Please ask for: Sian Eggington
Email: sian.eggington@terraquest.co.uk
Telephone: 0121 2341390
Our Ref: BR/175/21/HH
Your Ref:
Date: 5th July 2021

Application for Planning Permission for Works or Extension to a Dwelling

Development: Proposed single storey rear and side extension
Location: 2 Frith Road Bognor Regis PO21 5LL

PROPOSED  
Site Block Plan

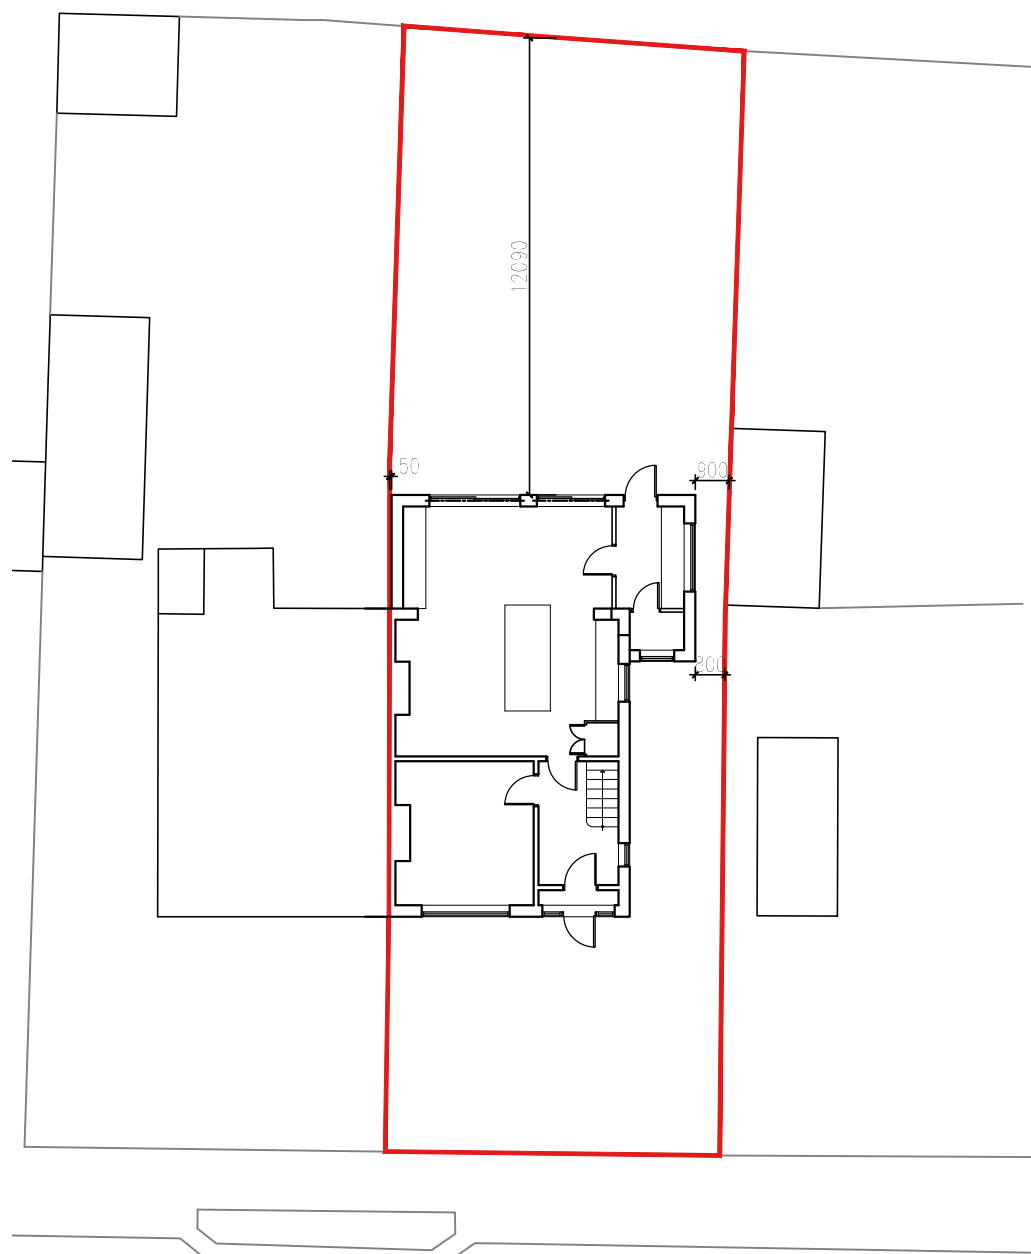
Block Plan

You are required to have dimensions from the proposed extension(s) to all site boundaries. Please amend
Elevations
